Application No: LU/305/21/PL
Site Address: Flat 17 Amstel Court Selborne Road Littlehampton BN17 5NR
Description of works: Replace windows with double glazed UPVC windows (This application may affect the character and appearance of the Littlehampton Sea Front Conservation Area)

OWPC41319

Objection

CLARE PATTEN
 17 ANSTEL COURT
 SELBORNE ROAD
 BN 17 5 NR
 WEST ELEVATION
 SCALE 1:100 @ A4
 DWG N° 17 AC/02

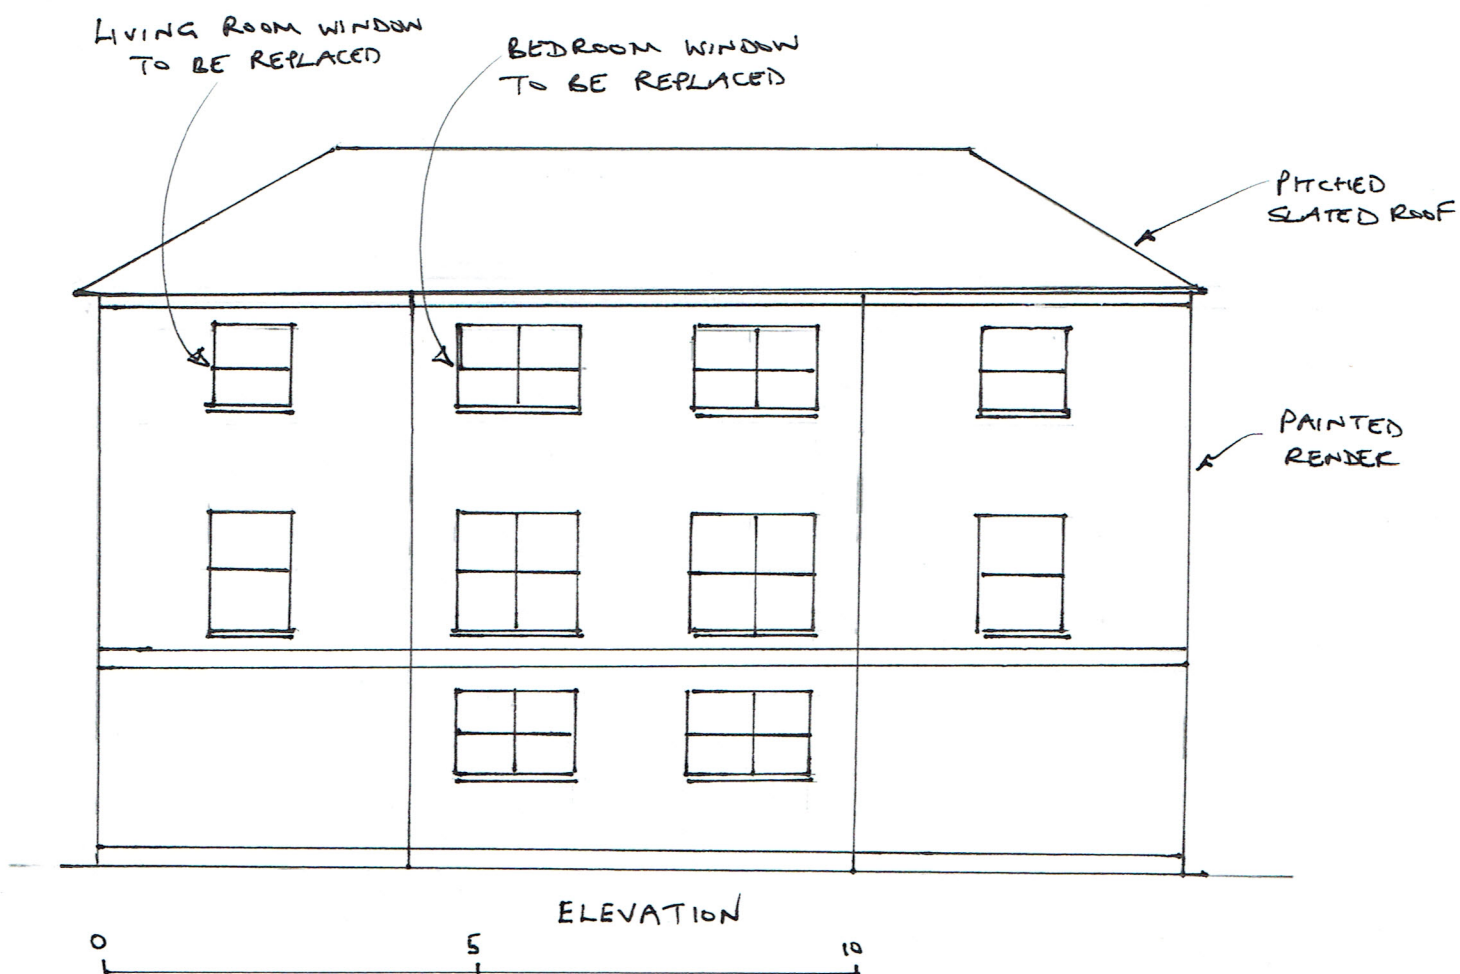
It is generally accepted that pvcu windows have a frame bulkiness, styling, finish, and commonly an operating mechanism which is not appropriate in relation to heritage assets.

Unfortunately, some of the original painted timber vertically sliding sash windows in the flats have been replaced with inappropriate top hung pvcu 'false sash' windows. These detract from the appearance of the blocks of flats and the conservation area.

Perhaps the Council should now draw a line and ensure that any new replacement windows, starting with the current proposal, are of an appropriate design and material which would be either painted timber single glazed vertically sliding sashes with secondary glazing (which apparently can now be formed of slimline double glazing) or painted vertically sliding timber double glazed sashes. Even the use of white powder coated aluminium vertically sliding sashes would be preferable to pvcu ones because more slender frame sizes can be more often achieved.

The grant of planning permission for the application as it stands will set a precedent for similar inappropriate fenestration in the remainder of the elevations leading to further harm to the visual integrity of the buildings and the character and appearance of the conservation area.

If the Council comes to the conclusion that it is unable to resist the use of pvcu in these particular buildings then, at the least, it should ensure that the sashes are plain (one over one), vertically sliding and not top hung, which would more closely match the existing original, traditional, ones.
